Application no: **3/2021/0985**

Address: **84 Whalley Road Clitheroe BB7 1EE**

Proposal: **Proposed single storey extension to the rear, removal of ceiling to second floor rooms and insertion of 3 conservation rooflights in rear roof pitch. New stud walls to form en-suite on the second floor. Removal of existing garage prior to construction of replacement.**

The Local Highway Authority have viewed the plans and highway related documents and have the following comments to make:

6410 - 02 R/B

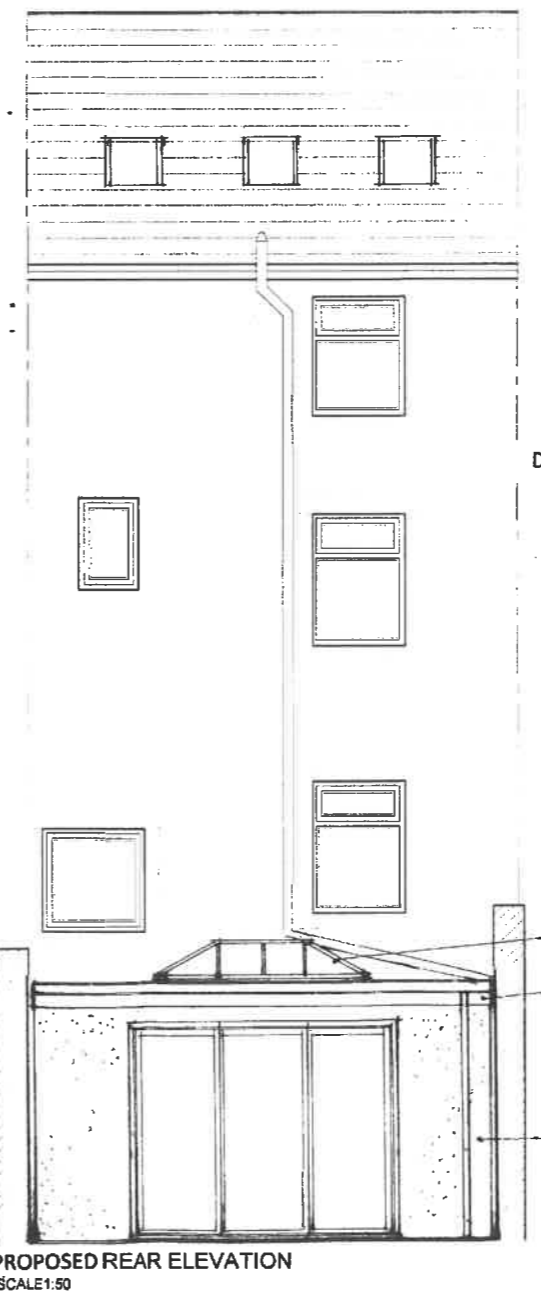
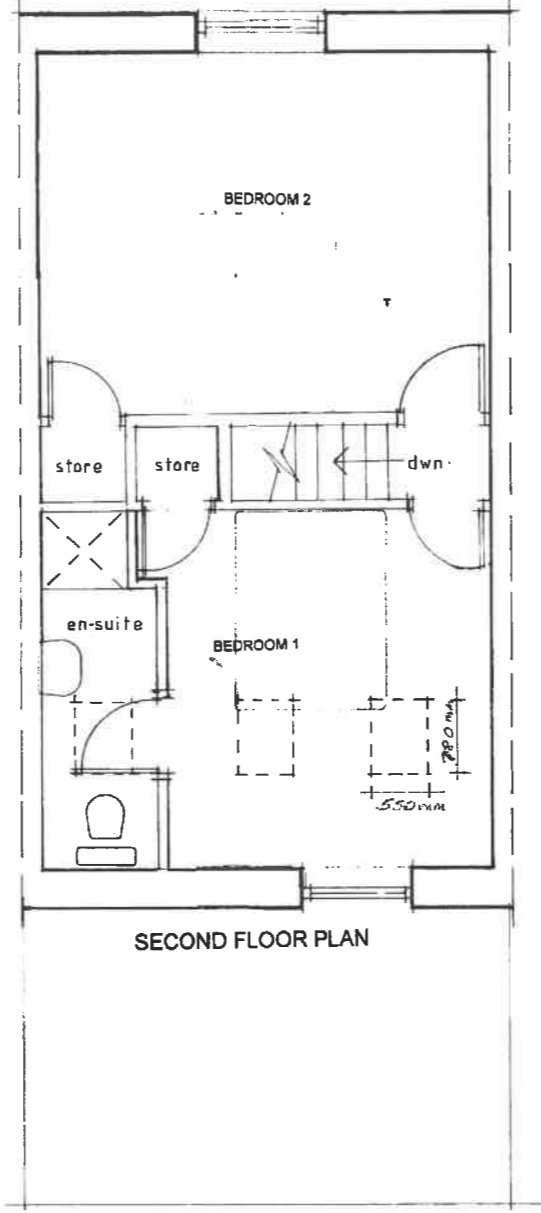
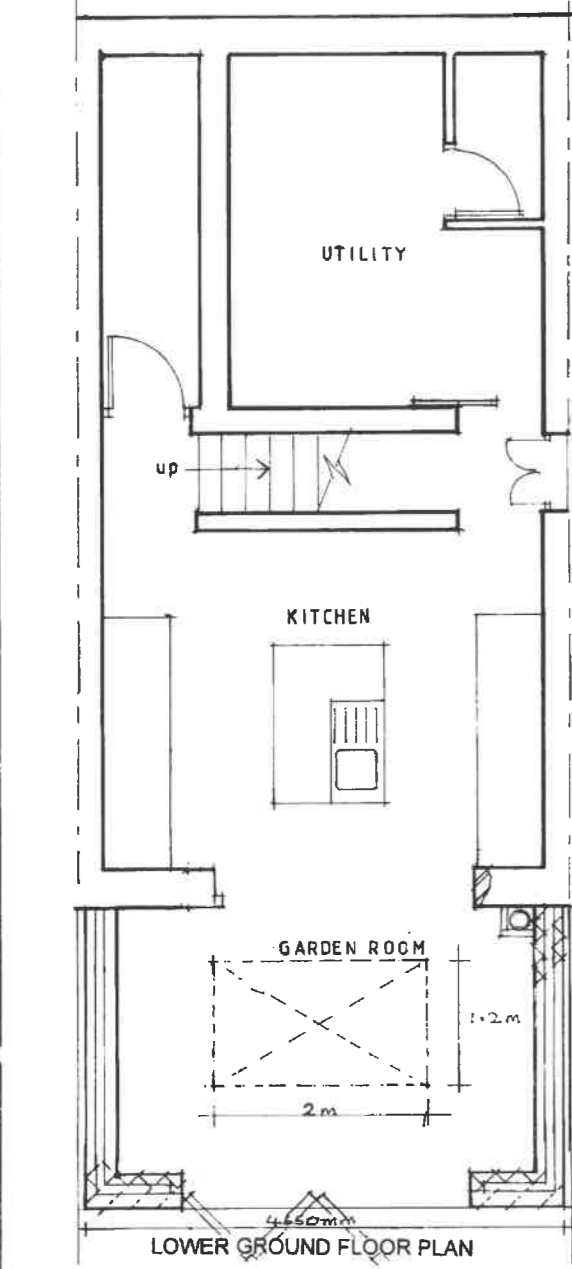
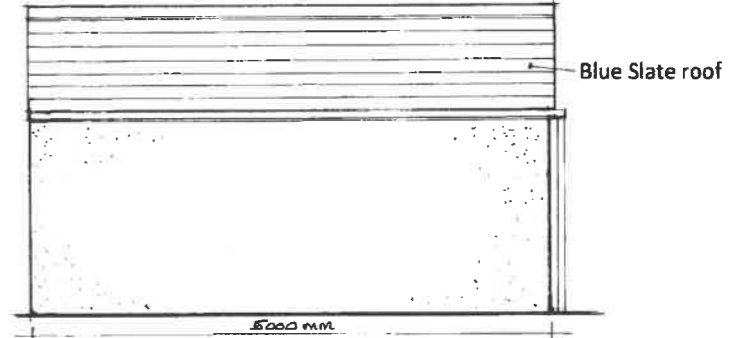
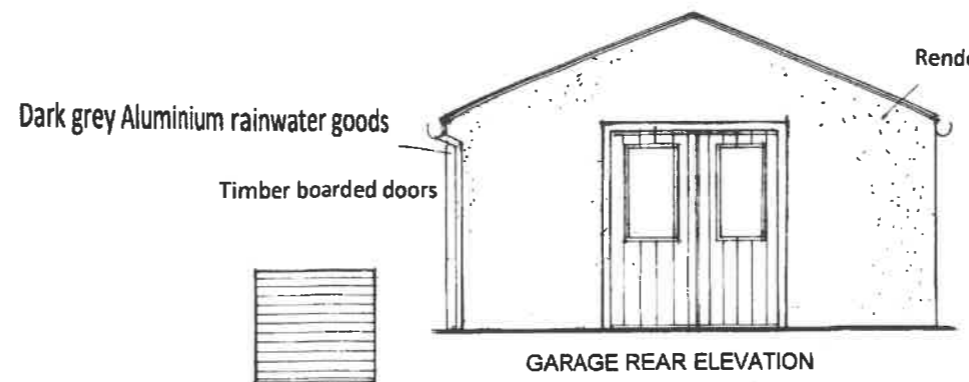
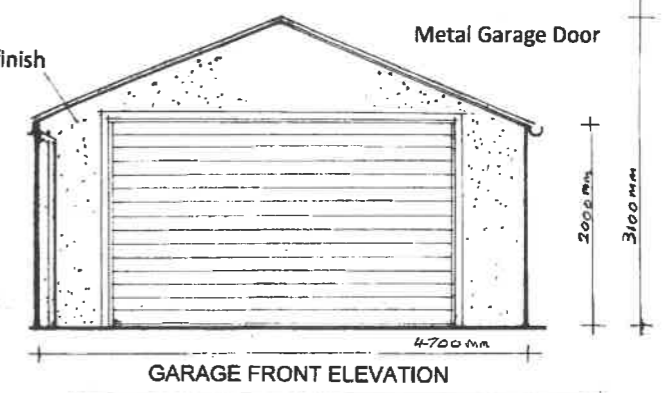
The LHA have reviewed SPA drawing number 6410-02 titled "Proposed Plans, Elevation and Section; Rev C with the dimensions to the drive added dated 15/11/2021" and are satisfied that the parking arrangements complies with the Joint Lancashire Structure Plan and so the LHA have no objection to the proposal.

1. The development hereby permitted shall not be occupied until such time as the parking and turning facilities have been implemented in accordance with SPA drawing number 6410-02 titled "Proposed Plans, Elevation and Section; Rev C with the dimensions to the drive added dated 15/11/2021". Thereafter the onsite parking provision shall be so maintained in perpetuity.
